**BEFORE THE HEARING EXAMINER FOR
MERCER ISLAND**

**In re the Application for a Reasonable
Use Exception for Property at 5637 East
Mercer Way**

CAO15-001

RE: Notice of Incomplete Application for File No. CAO15-001 at 5637 East Mercer Way, Parcel 1924059312

BOUNDARY / TOPOGRAPHIC SURVEY No. Data Bl./Col.	1 1
	1 1
CHS ENGINEERS, LLC 5637 EAST MERCER WAY MERCER ISLAND, WA TEL: (425) 877-9699 FAX: (425) 877-9384 WWW.CHSENGR.COM DATE: 11-14	SUMMERS DEVELOPMENT SHEET 1 OF 1 JOB NO. 001411

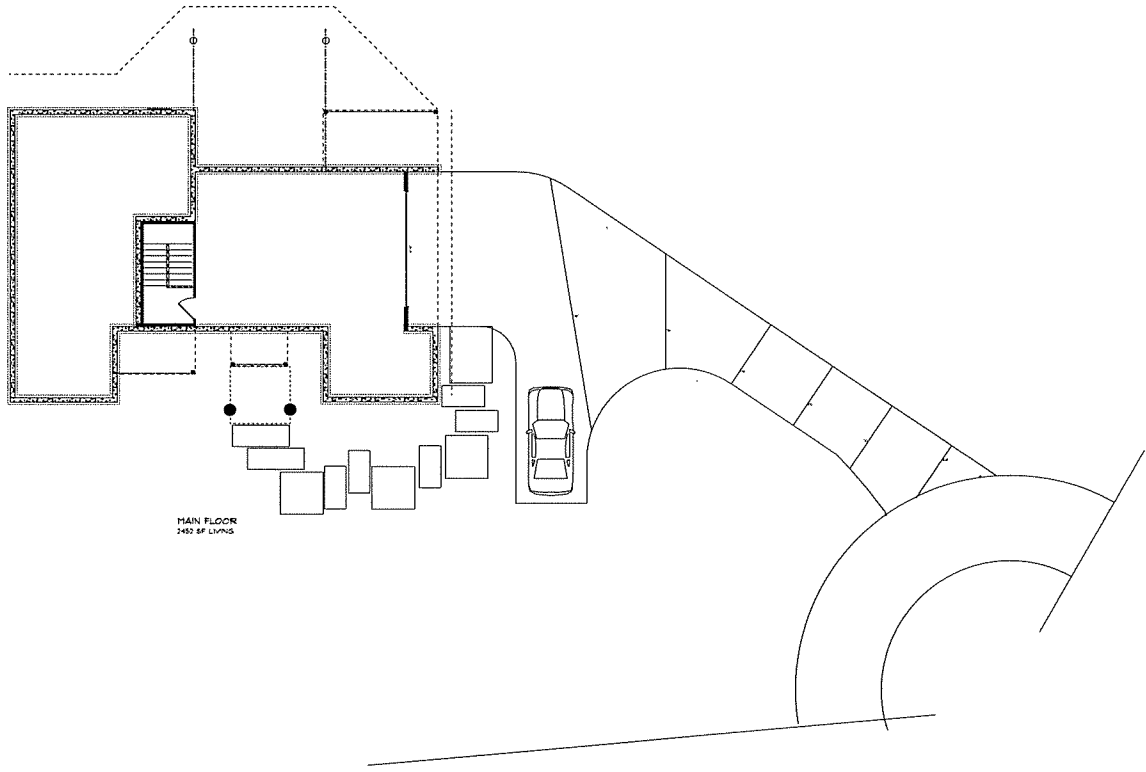
- ✓ Property boundary lines
- ☐ Building setbacks/yards – *Please show setbacks on the proposed site plan (CHS Engineers Sheet 1 of 1). Please see 19.02.020(C).*

- ✓ Existing structures
- ☐ Proposed structures – *The storm detention vault is described as being located within the driveway. The site plan shows the storm detention vault partially within the driveway, partially outside the driveway. Please resolve this discrepancy. Please also indicate point of discharge as well as the location of other utilities. Additionally, please show all proposed structures on all applicable documents, including the critical areas study;*

- ☐ Existing Critical Areas (i.e. wetland boundaries, OHWM of watercourses) – *The site plan does not clearly delineate the critical areas and their associated buffers. Please clearly label.*

- ☐ "Standard Buffers" for wetlands and watercourses, as specified by MICC 19.07.070.A and 19.07.080.C - *The site plan does not clearly delineate the critical areas and their associated buffers. Please clearly label.*

- ☐ Proposed alterations of Critical Areas – *Please clearly define extent of disturbance, which includes any proposed clearing and grading.*
- ✓ Adjacent streets

- ☐ Drawn to scale – *Measurement of the site plan using the stated scale of 1"=20' indicates that the site plan is distorted, likely a printing error. Please provide a site plan that is correct to the stated scale.*

- A. Site survey – *The survey/site plan (CHS Engineers, page 1 of 1) does not contain a surveyor seal or signature, and as such, is not considered a survey. Please provide a current survey that is sealed and signed by a licensed professional land surveyor. The survey needs to delineate critical areas, pursuant to 19.07.050.*
